Stage 1 RSA 2nd Addendum - Response Report

1.1 This report results from receipt of a Stage 1 RSA Addendum 2 Report, undertaken dated February 2018.

Persimmon Homes Thames Valley
North Littlehampton, Lyminster Bypass (Southern Section)
Stage 1 RSA 2nd Addendum – Response Report

drawing number
A/PHLYM.1/TK-1

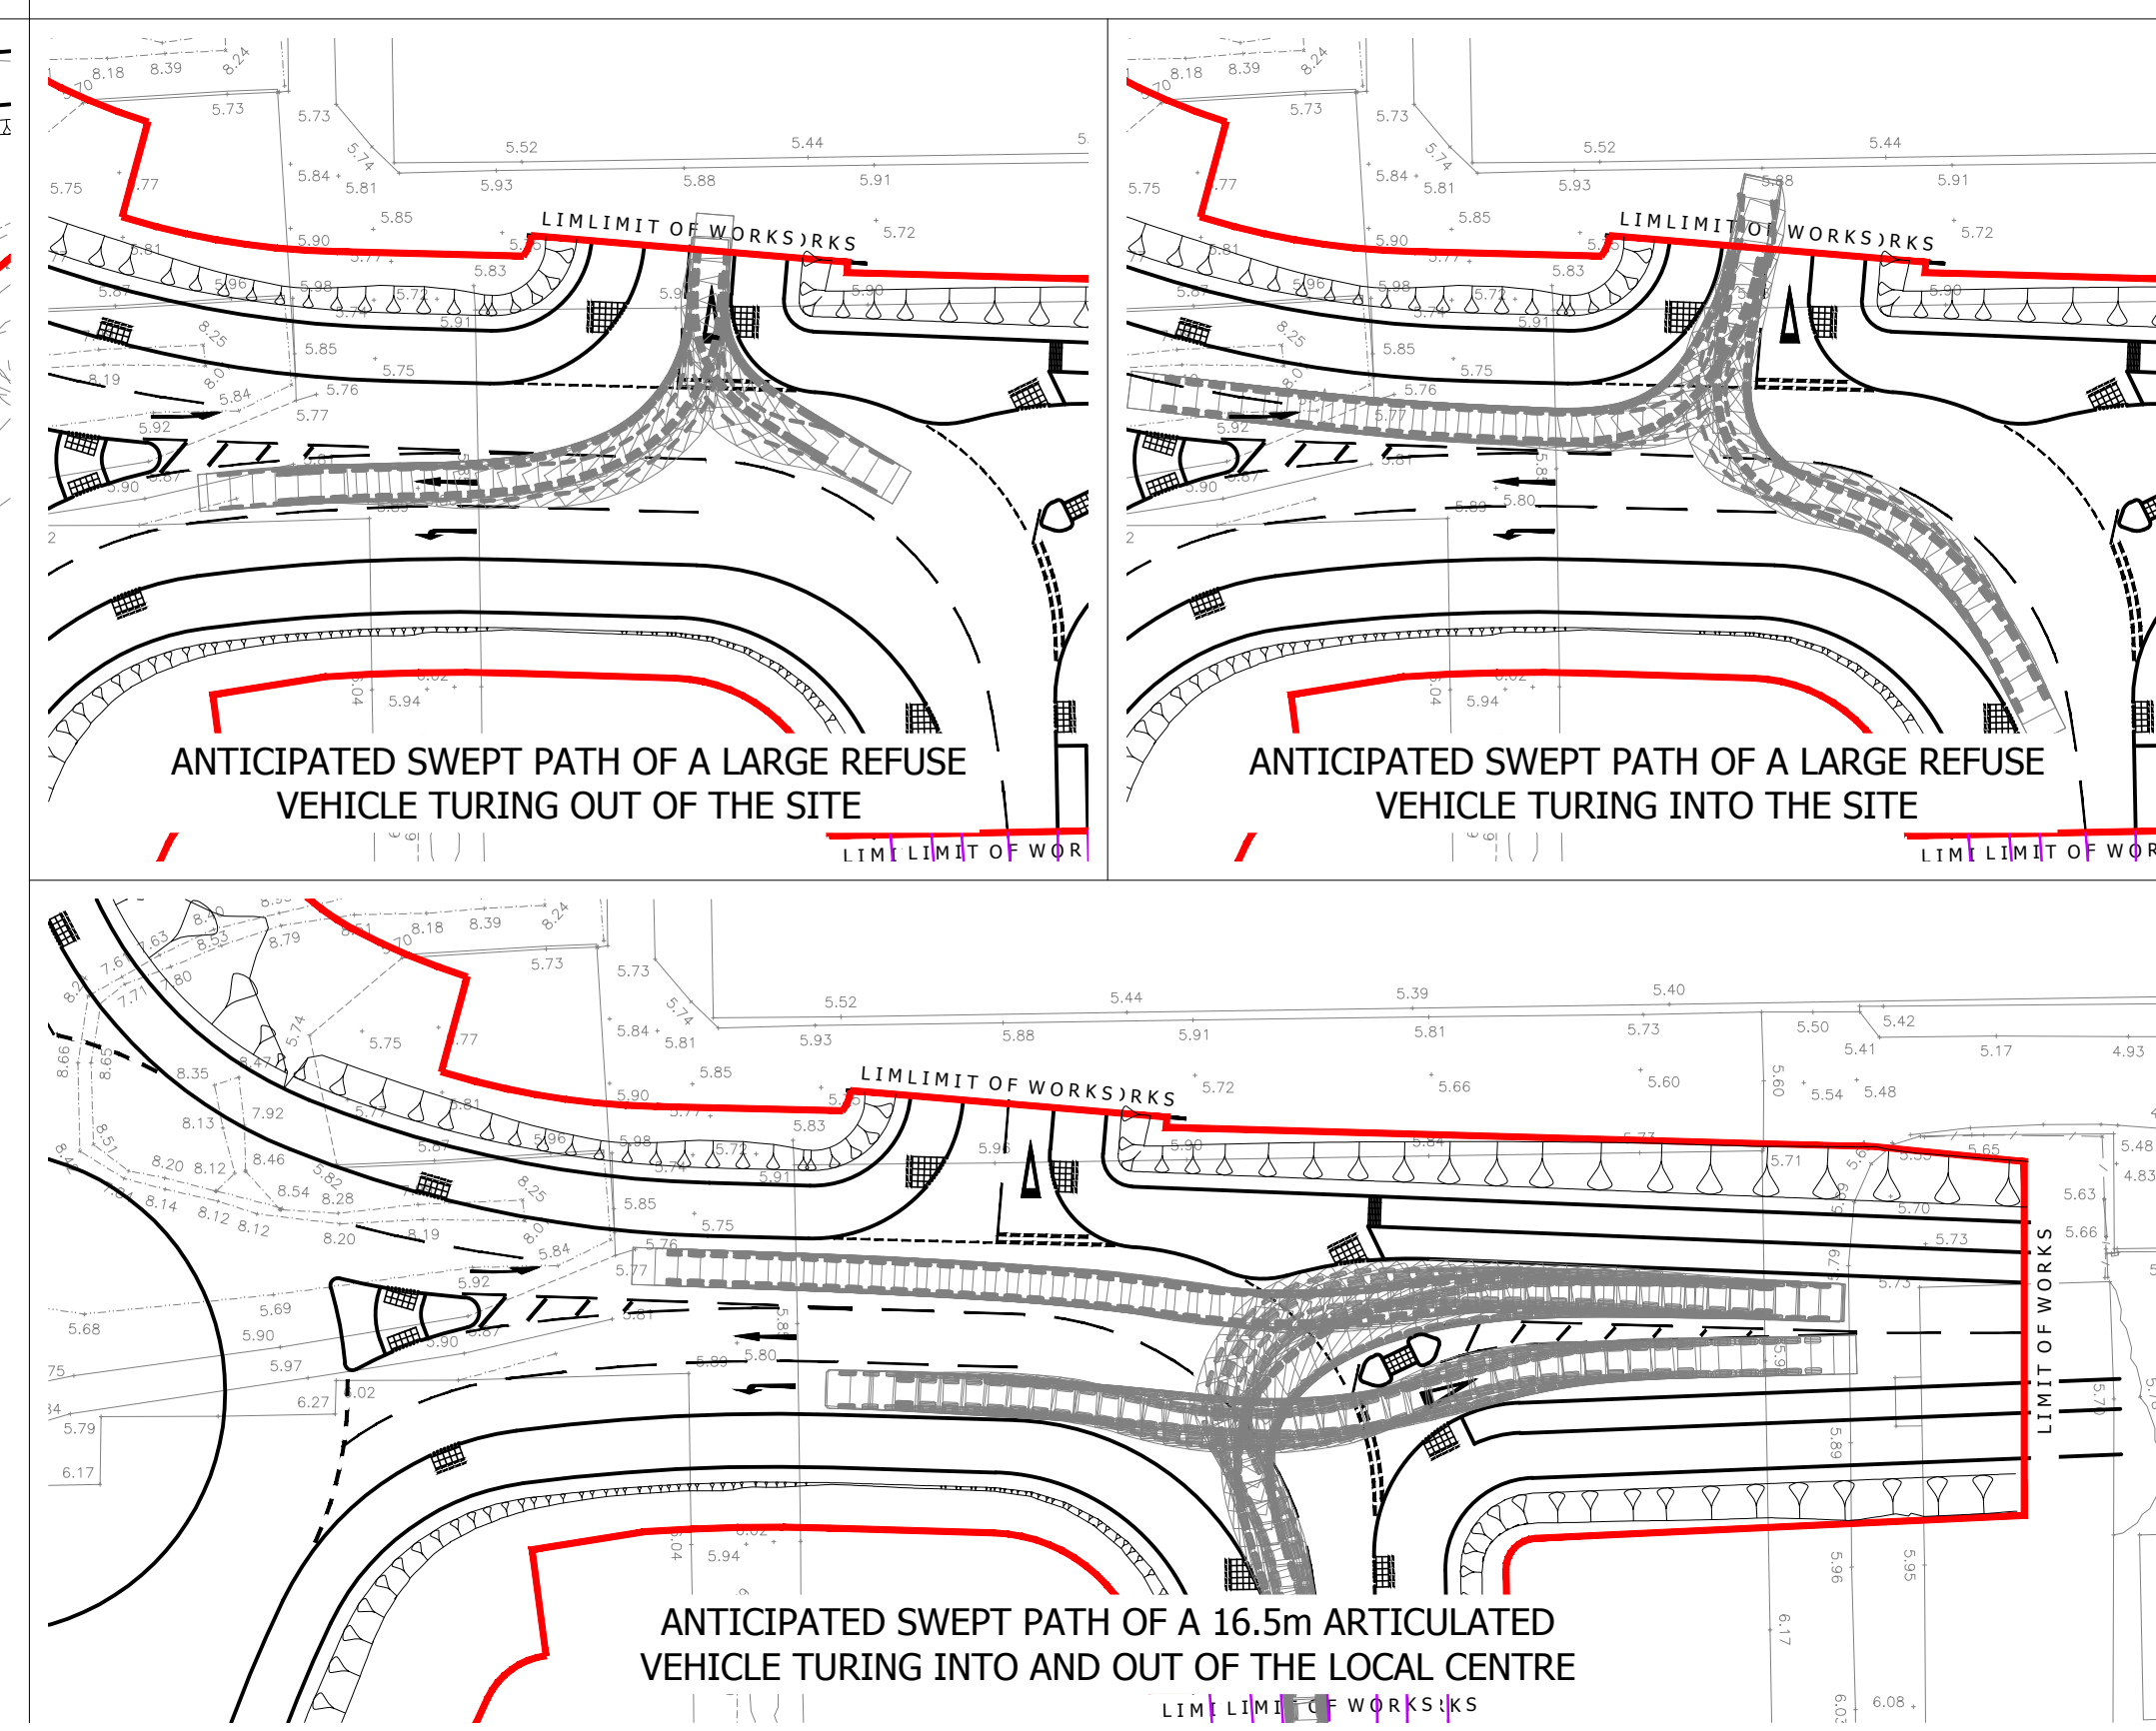
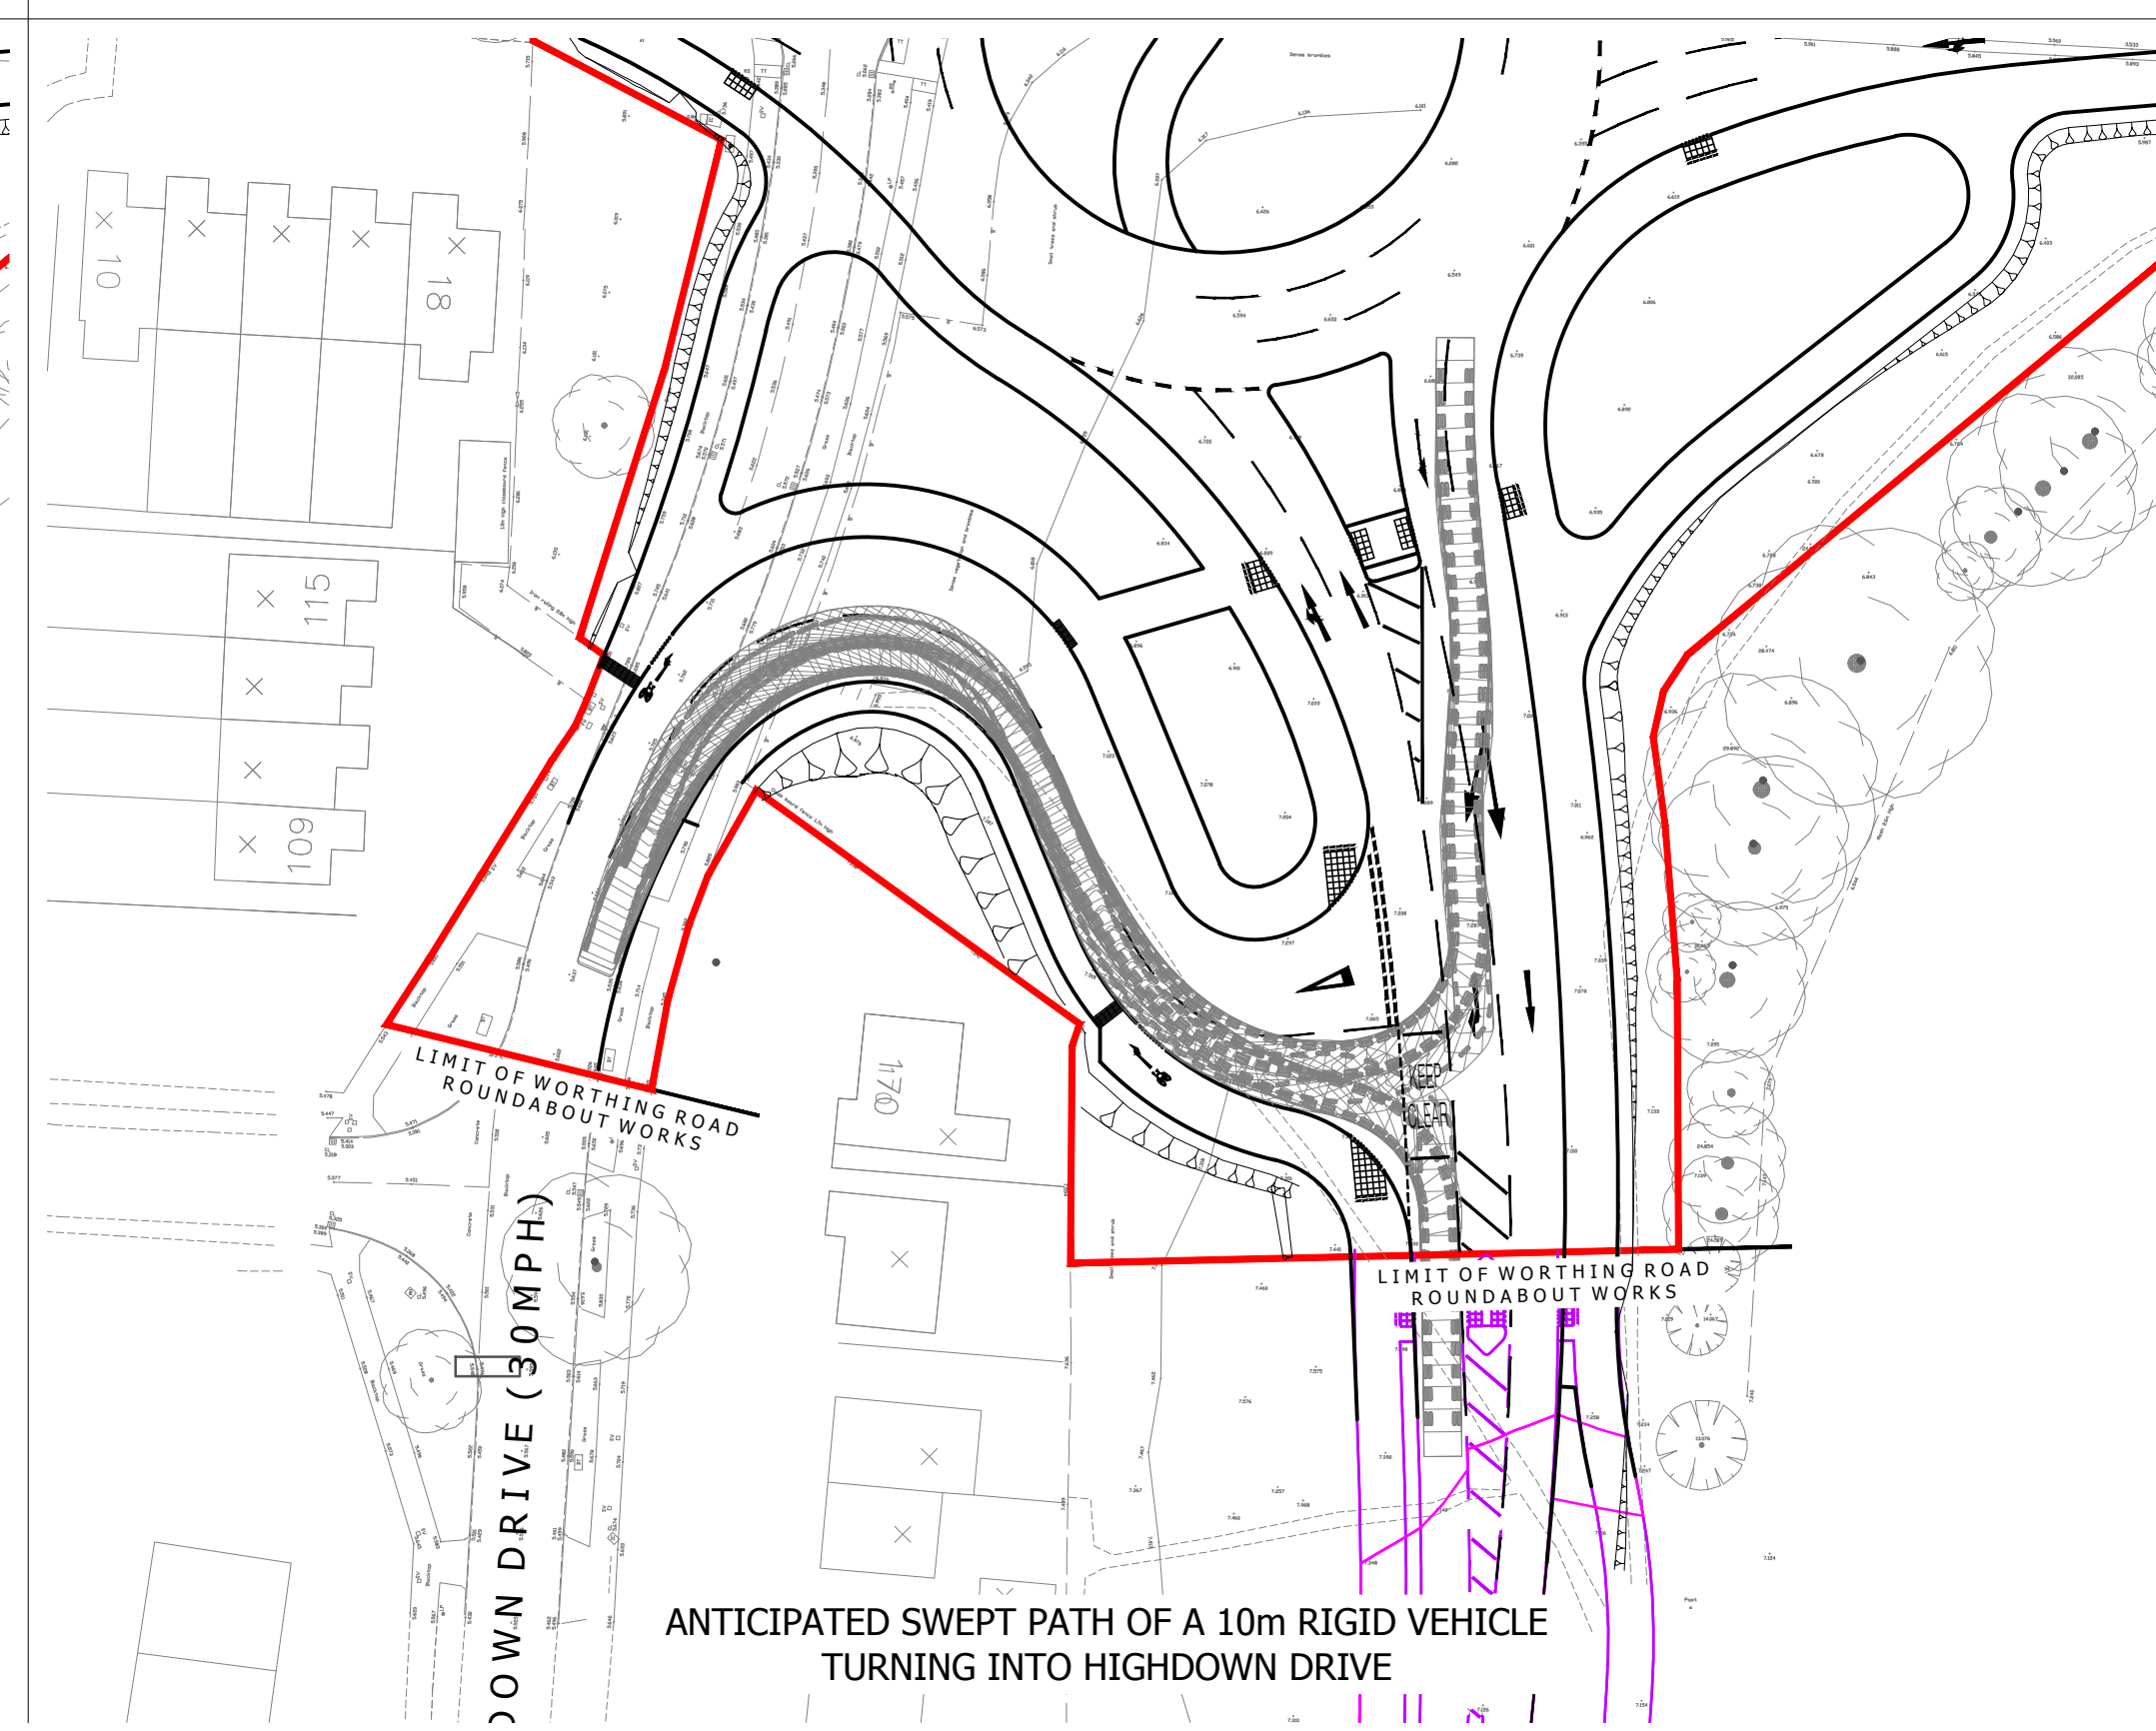
Item	Problem	Recommendation	Designer's Response
3.3	Location: General. Summary: Proposed signage This matter can be dealt with at the detailed design stage. It will be important that the new highway network is clearly signed throughout. - There appears to be insufficient signage provided on the bypass on each approach to the proposed roundabout junctions. - Whilst map-type signs are generally detailed on approaches to the roundabout junctions, there are no map-type signs detailed on the new bypass. - Visibility to proposed road signs (bypass) has not been shown at this stage. - Whilst details of sign types, dimensions and locations have been generally detailed. Sign posts should not be located where they will cause an obstruction/hazard to pedestrians/cyclists. For example, one of the two posts supporting the map-type sign on the eastbound approach to the A259 Worthing Road roundabout junction is located in the centre of the footway.	- Provide signing on each approach to new and modified junctions. - Map-type signs will be required at roundabout junctions. - Ensure adequate forward visibility to signs and ensure adequate clearance between sign face and carriageway. - Where appropriate ensure adequate clearance for pedestrians and cyclists beneath sign face. ~~Provide maximum speed limit signs at all changes of speed restriction.~~ This no longer remains relevant as maximum speed limit signs are provided at all changes of speed restriction	Accepted. - Appropriate signing shall be provided at detailed design stage through agreement with the Highway Authority. - Map type advance direction signs shall be provided on each approach to the junctions as recommended. The initial traffic signing locations indicated on the drawings are provided to show the intention to provide advance and direction signing. - Adequate visibility to traffic signs shall be provided. Adequate clearance between the sign face and carriageway shall be provided as recommended. - A clearance of 2.40m shall be provided beneath sign faces for pedestrians and cyclists. <i>An initial signing strategy has been developed for review by WSCC and includes ADS signs on the Bypass approaches to the roundabouts (MB drawing numbered A/PHLYM.1/TS01 Rev P1). It is intended that this will be discussed further and agreed at detailed design stage.</i>
